**REQUEST**

Current Zoning: N1-A (neighborhood 1-A) and CG (general Commercial)  
Proposed Zoning: N2-B(CD) (neighborhood 2-B, conditional)

Approximately 16.15 acres located at the northeast intersection of Beatties Ford Road and Trinity Road, south of Lakeview Road.

**SUMMARY OF PETITION**

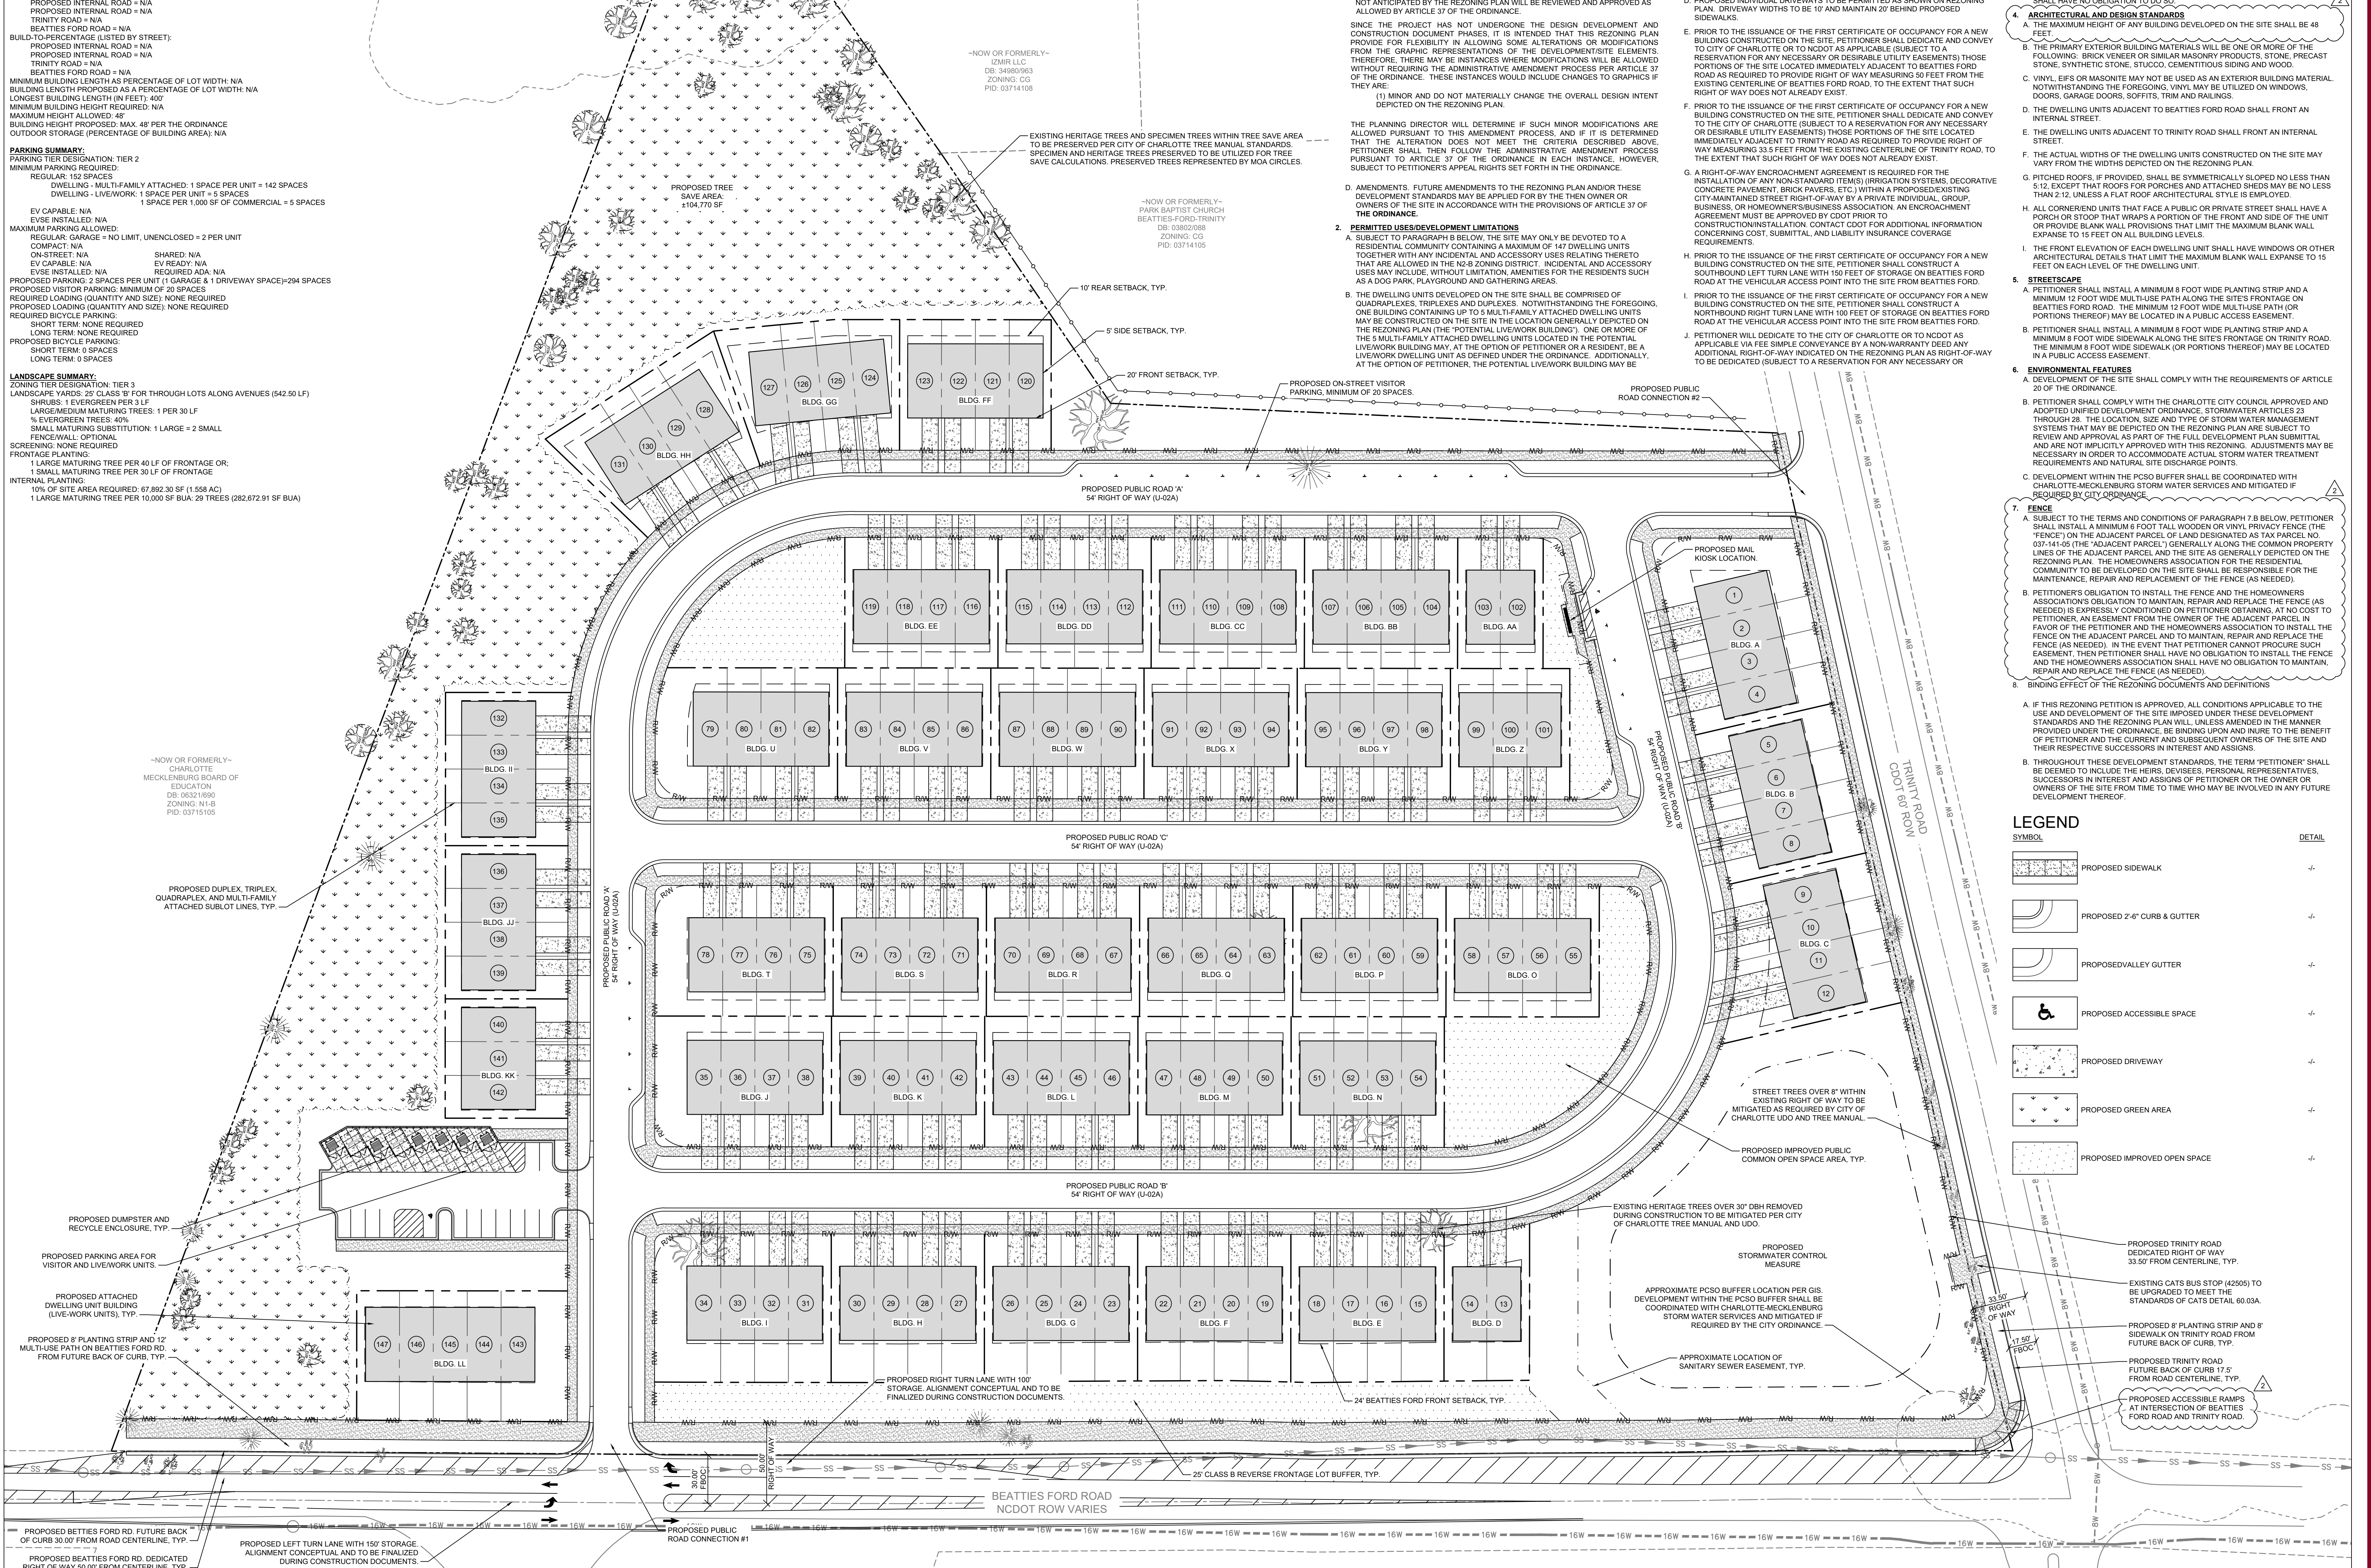
3. CTR commitments were removed from table. Please update table to match previous site plan submittal from February 2024.
